From: Contact Centre (CRM) <contact@ribblevalley.gov.uk>
Sent: 18 November 2023 10:56
To: Planning
Subject: Planning Application Comments - 03/2023/0802 FS-Case-562994385

Planning Application Reference No.: 03/2023/0802

Address of Development: 83 St Marys gardens

Project Proposed extension to 83 St Mary's Gardens, Mellor, BB2 7JP	
Description Existing Site Plan	Date Sept 2023
Client Mr. & Mrs. G. Hayes	Drawn CW
Scale 1:100 @ A3	Drg No 348/01/04B

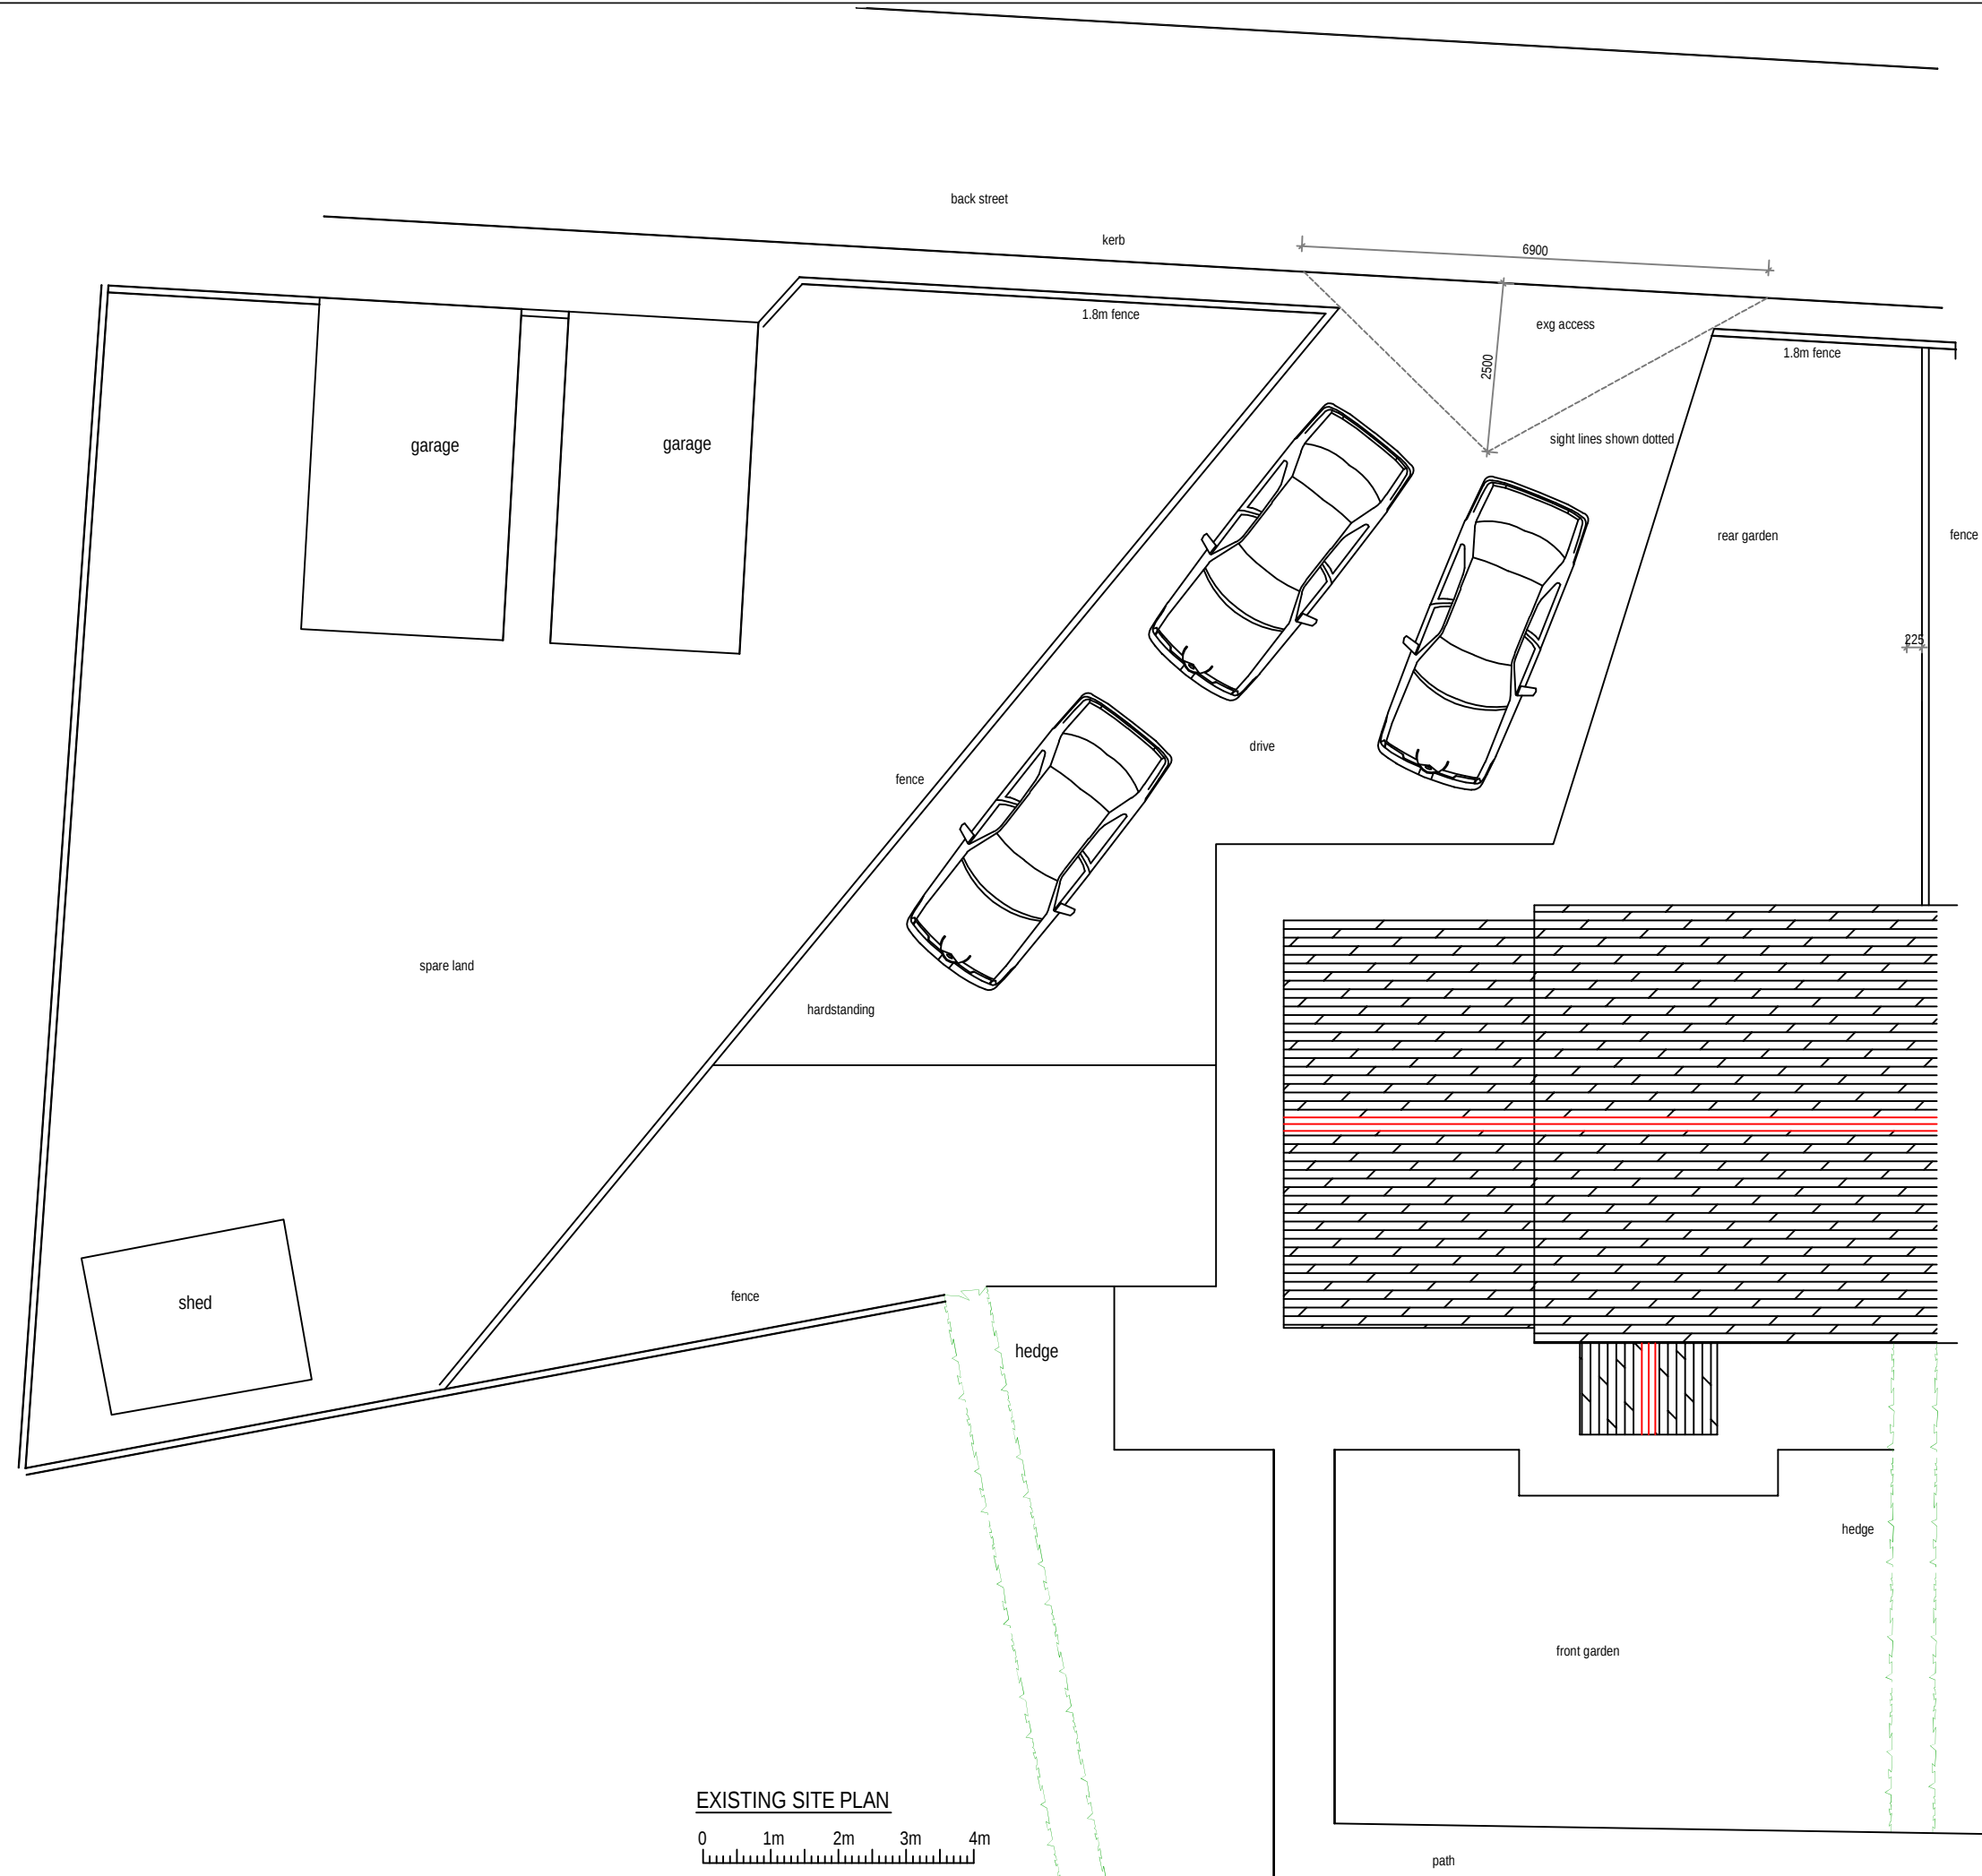
Comments: The proposed layout isn't clear as to who will be able to park there. The land facing the original garages (adjacent to the heys property) is council land and now seems to be being used to store vehicles and used by the Hayes which I have no real concern with. What I would like confirmation of is that this planning application doesn't provide sole rights to the Hayes to use that land. If you can please confirm the lane boundary and that the land shown for vehicular access is still public property and therefore open for any nearby residents to park in? This land could provide essential parking considering the situation on Mellor lane where people have very little parking available to them.
